BENT GRASS EAST COMMERCIAL FILING 3

PRELIMINARY PLAN

PCD #: SP-20-010

COVER SHEET

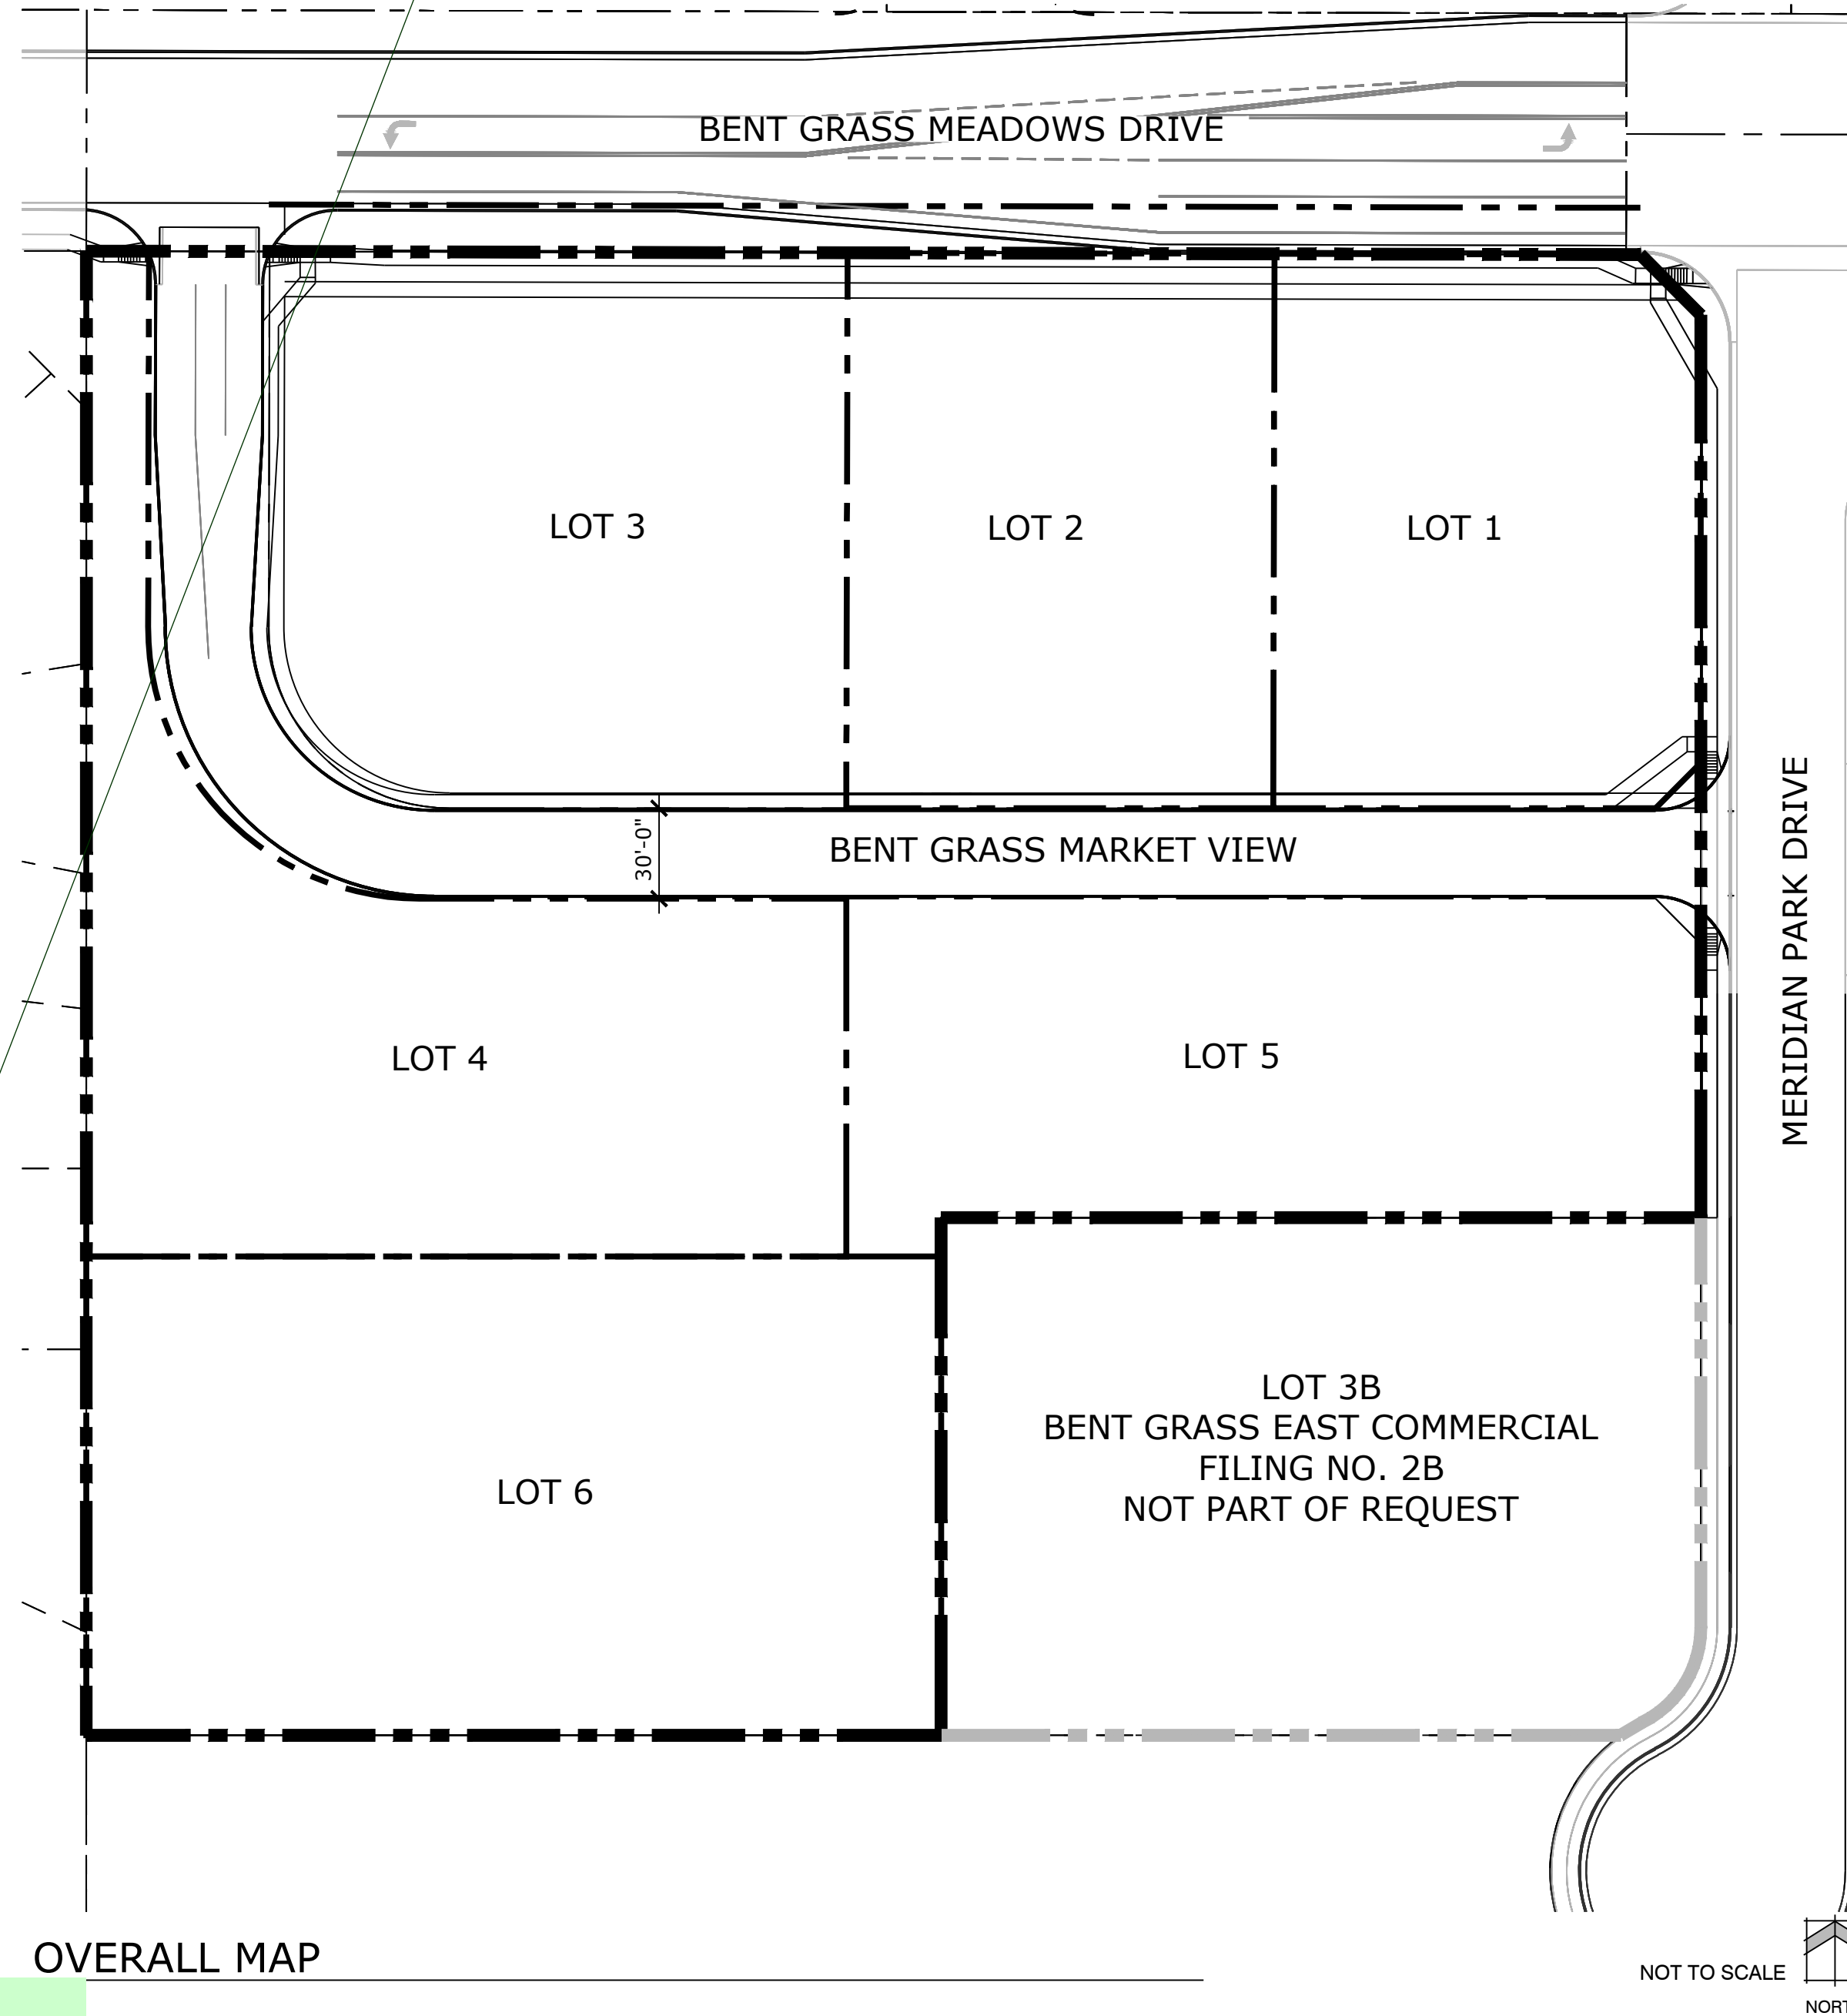
correct legal to include requirement on old checklist

Legal includes approximate survey tie to an accepted survey monument?

Legal has been updated to match recorded legal. Per meeting with County, legal on title block meets preliminary plan review criteria

LANDSCAPE NOTES AND DETAILS

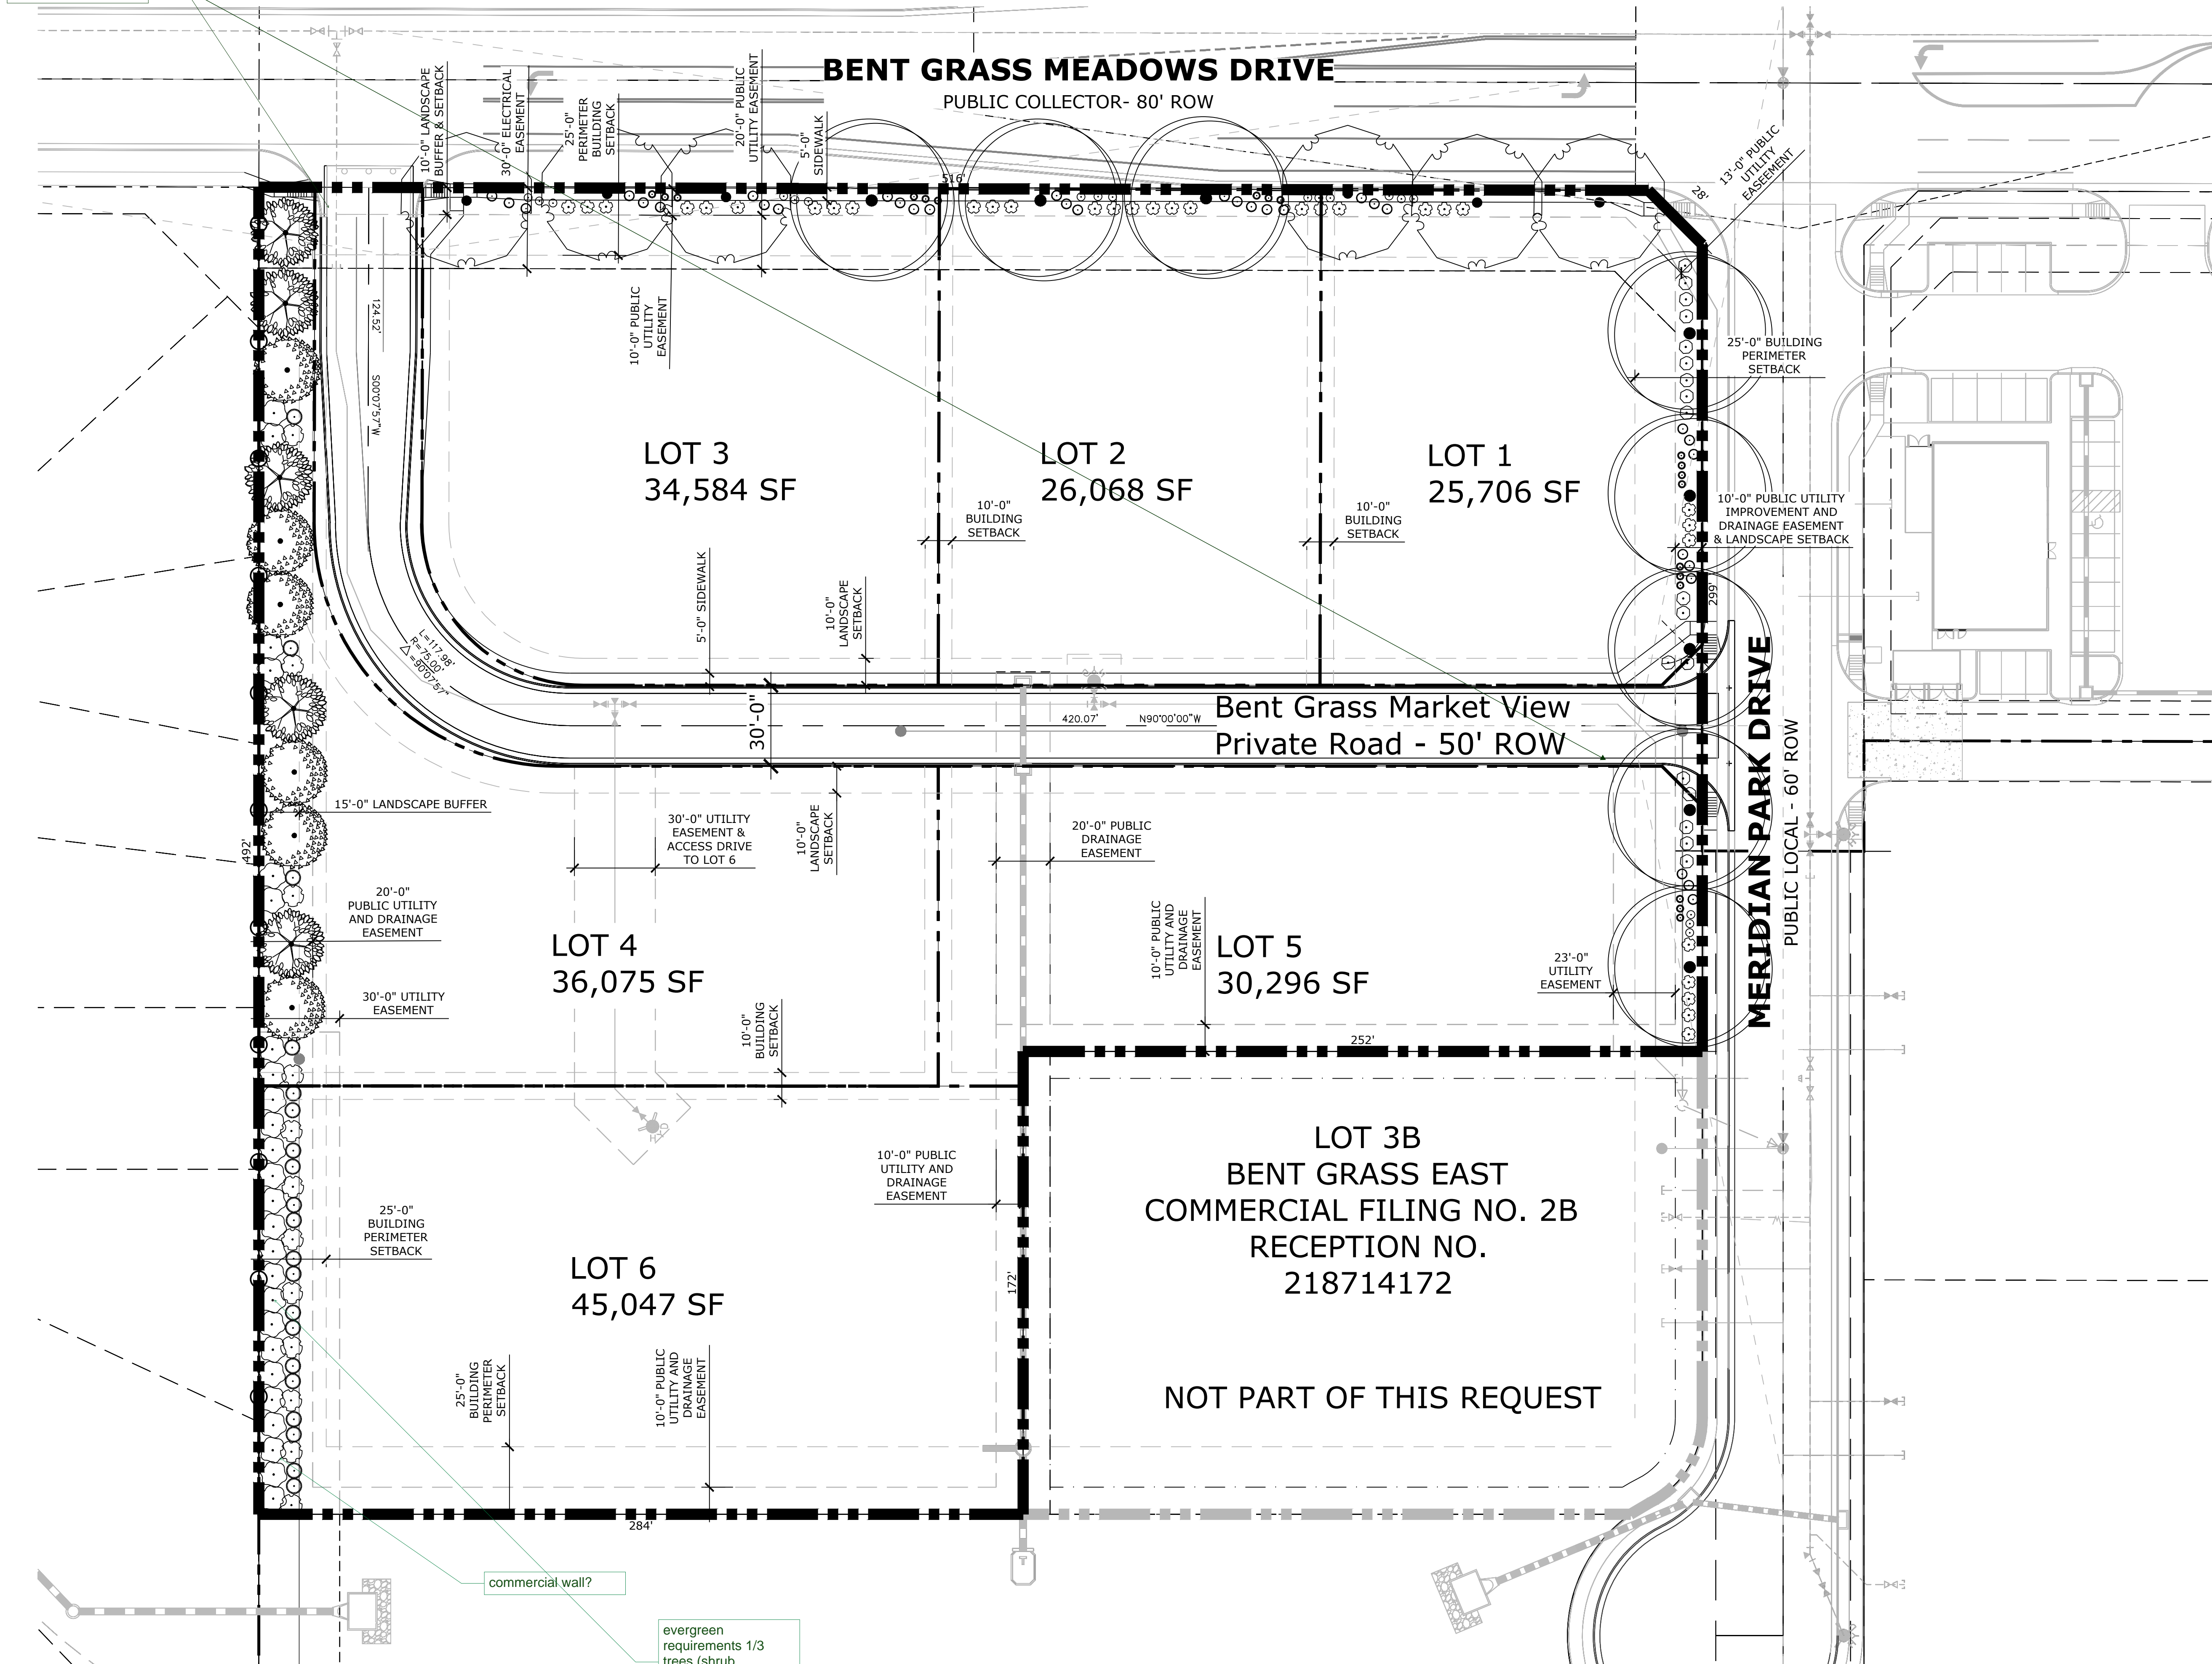
EVERGREEN TREE REQUIRED / Please show calculations for required for roadway and buffer

provide the commercial wall as required.

the commercial is responsible for the wall not the residential. Have you obtained a letter from the individual property owners that they agree to maintain the existing fence not wall on ? Do they support a waiver of the opaque wall being installed and maintained by individual lot owners not commercial to support the waiver of the requirement for the commercial to provide the wall?

there is no requirement for the lot owners to have a fence; it is on the commercial. Maybe the commercial would like provide a maintenance agreement for fencing or replace the fence w concrete or CMU block? Staff will likely note the issue in the staff report

A 15' buffer has been added along Bent Grass Meadows Drive with over 1/3 evergreen trees proposed.

Per discussion with the County, Bent Grass Merchants Association will maintain the existing 6' Cedar Fence on the Residential Properties and 15' of vegetation between the residential and commercial uses.

Per discussion with the County, Bent Grass Merchants Association will maintain the existing 6' Cedar Fence on the Residential Properties and 15' of vegetation between the residential and commercial uses.
